22 July 2020

**Supplementary Response to Submissions
Multi-Trades and Digital Technology Hub, TAFE NSW Meadowbank Campus, Meadowbank
Education and Employment Precinct (SSD 10349)**

Further Project Amendments

5 LEVEL 5
DA20 SCALE 1:500

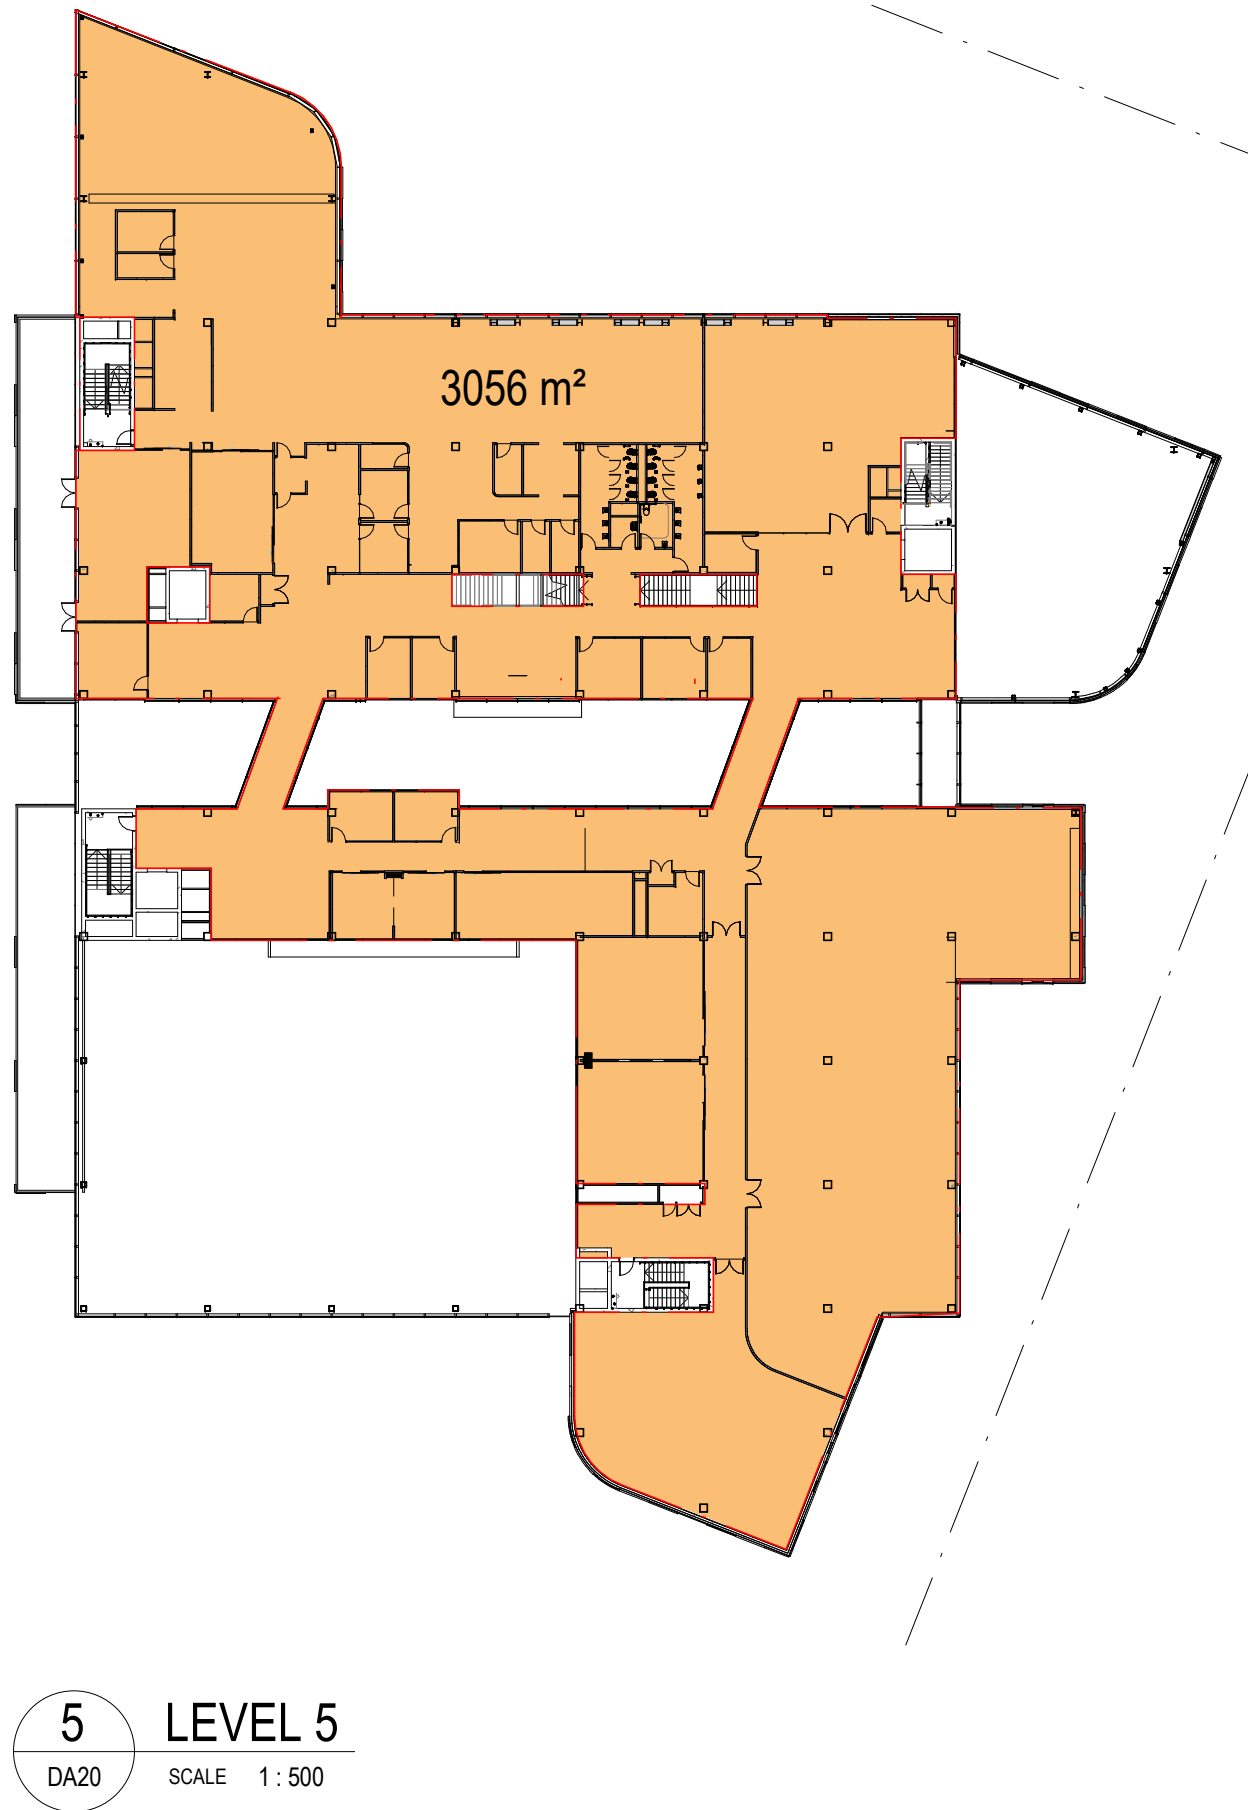
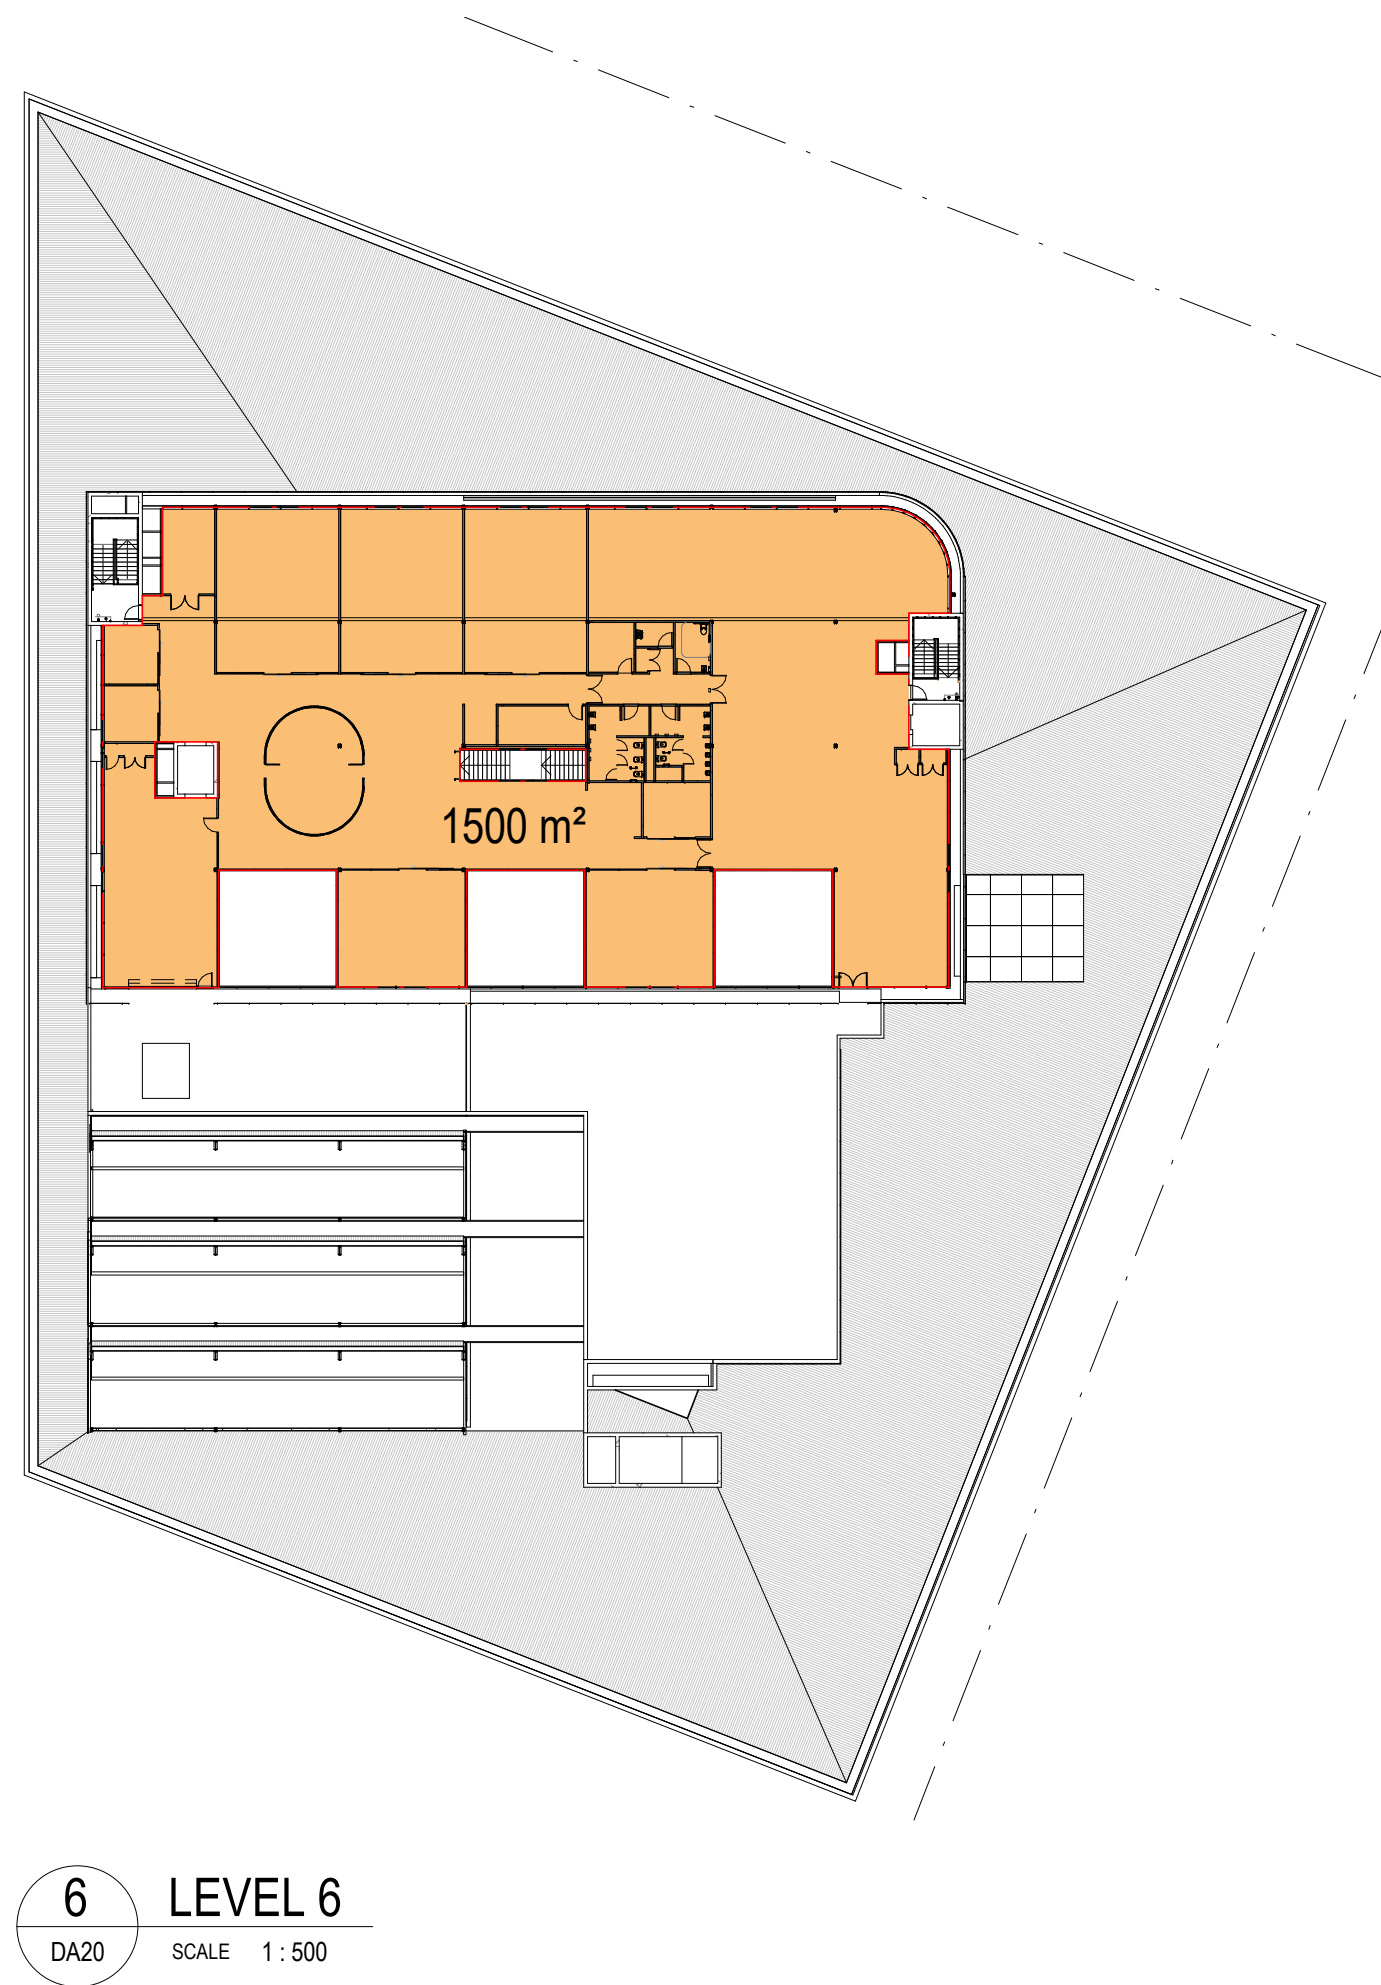
Plan Number	Revision	Date	TR-LA-DWG-C0100	2	12/06/20	219-0066-02_SSDA_100	3	29/01/20
Plan Number	Revision	Date									
TR-LA-DWG-C0100	2	12/06/20									
219-0066-02_SSDA_100	3	29/01/20									
A8	Confirm whether GFA Plan DA50 B needs to be updated.	<p>Drawing No. DA50 has been updated (Revision C and dated 08/07/2020) to reflect the amended layout of the Hub due to the introduction of the multi-storey car park.</p> <p>It is noted that the multi-storey car park is not included on this plan. In accordance with the definition of gross floor area included within the Educational Establishments and Child Care Facilities SEPP car parking is excluded for the purposes of calculating GFA.</p> <p>gross floor area means the sum of the floor area of each floor of a building measured from the internal face of external walls, or from the internal face of walls separating the building from any other building, measured at a height of 1.4 metres above the floor, and includes—</p> <ul style="list-style-type: none"> a) the area of a mezzanine, and b) habitable rooms in a basement or an attic, and c) any shop, auditorium, cinema, and the like, in a basement or attic, but excludes— d) any area for common vertical circulation, such as lifts and stairs, and e) any basement— <ul style="list-style-type: none"> (i) storage, and (ii) vehicular access, loading areas, garbage and services, and f) plant rooms, lift towers and other areas used exclusively for mechanical services or ducting, and g) car parking to meet any requirements of the consent authority (including access to that car parking), and h) any space used for the loading or unloading of goods (including access to it), and
